### **Deep Creek Quarry (SSD-11591659) – Review of Response to Submissions Report**

**6 February 2023**

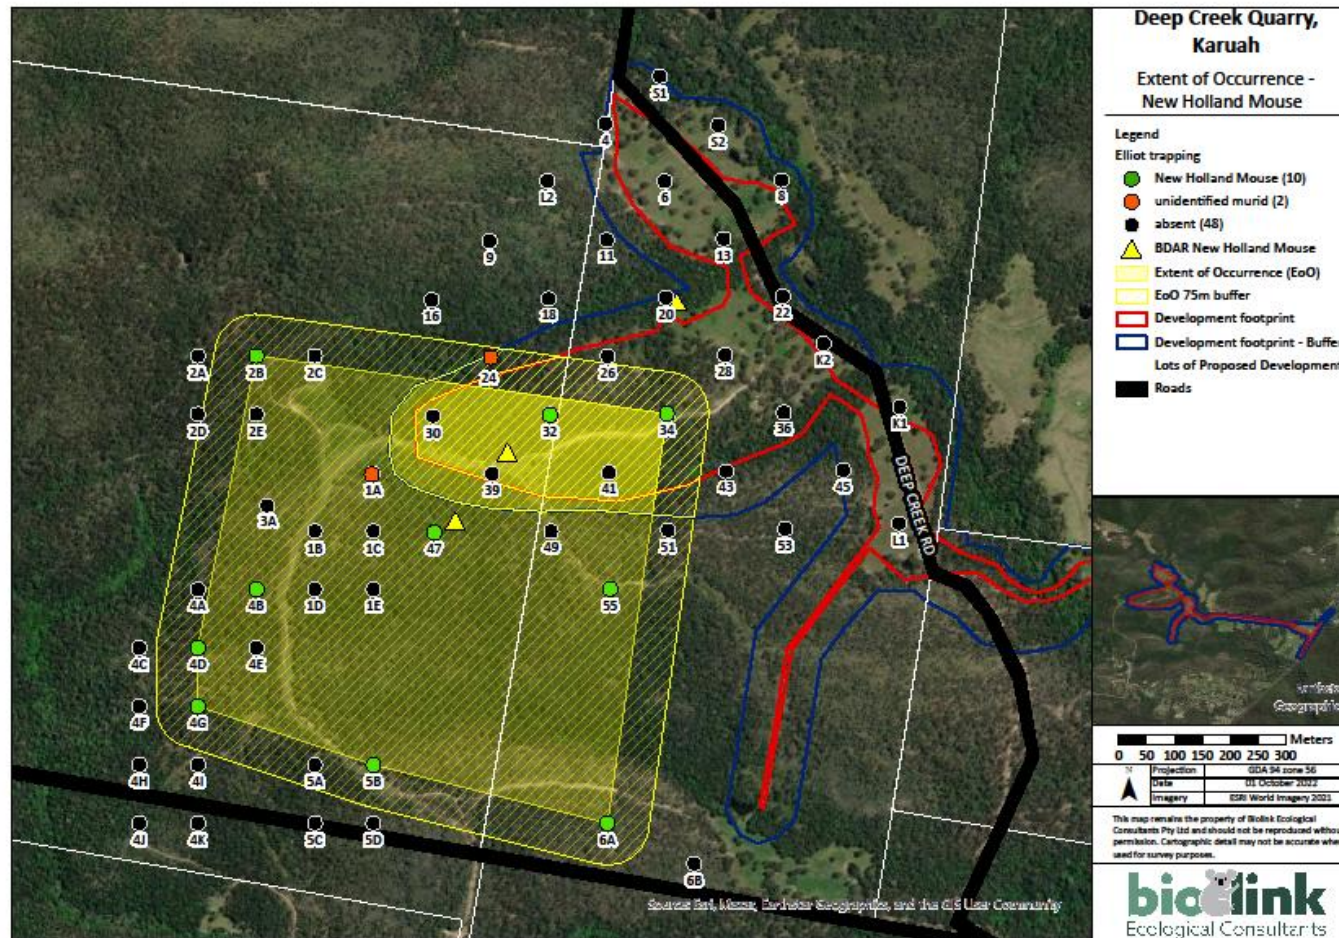
- GIS shapefiles of the maps in Figures B1 to B8, inclusive, from Appendix 8 of the BDAR.
- Justification of the survey approach used for the New Holland mouse, particularly by way of peer-reviewed publications, particularly in relation to the spacing of Elliot trap sites that differ from the recommended 20 to 50 metre spacing in the 'Threatened Biodiversity Survey and Assessment: Guidelines for Developments and Activities: Working Draft' (DEC, 2004).
